Planning Services Sign Permit Review Form

Date of Submittal	Application Number	Applicant	Landowner
4/26/2023/ Resubmitted 5/17/2023	SIGN2304-0004	Weller Developers	Wellers Knoll HOA Inc.

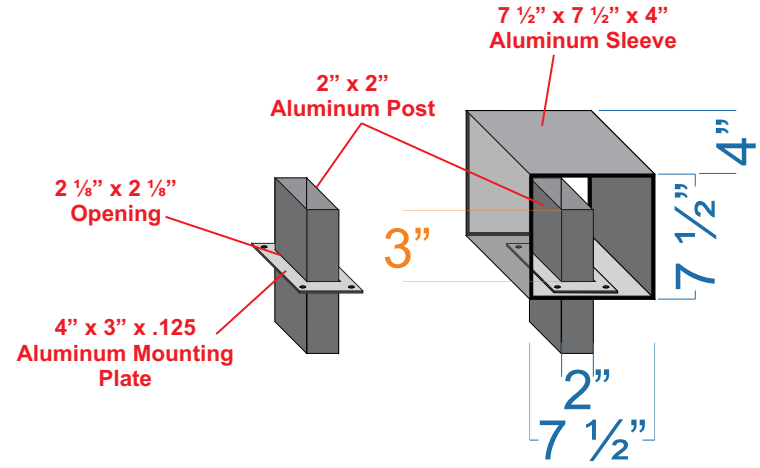
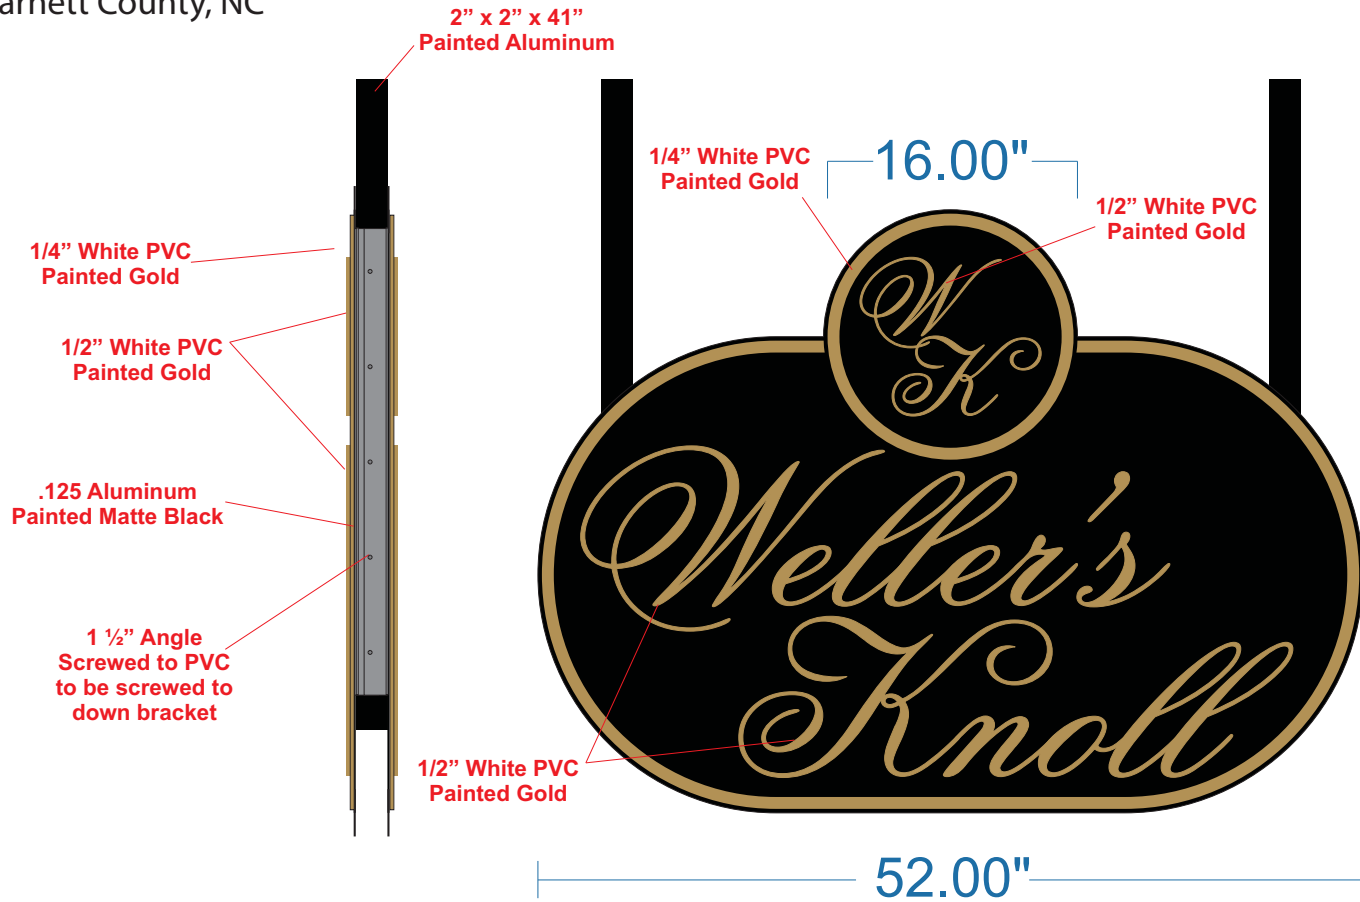
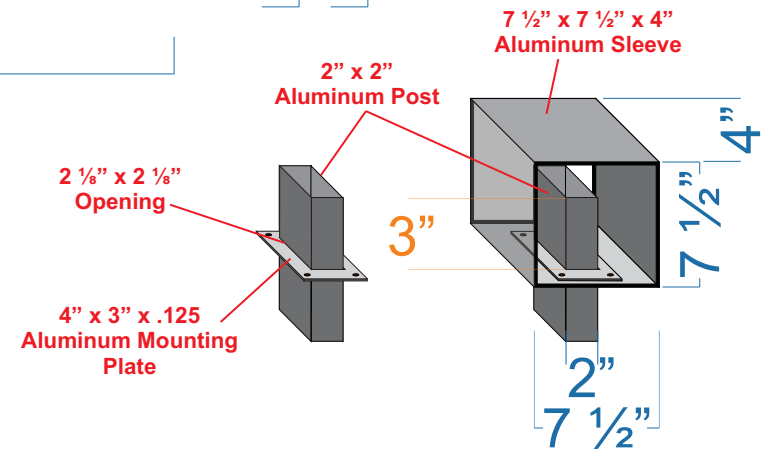
Comments	1 single faced sign per entrance, 50 Square feet maximum.
----------	--
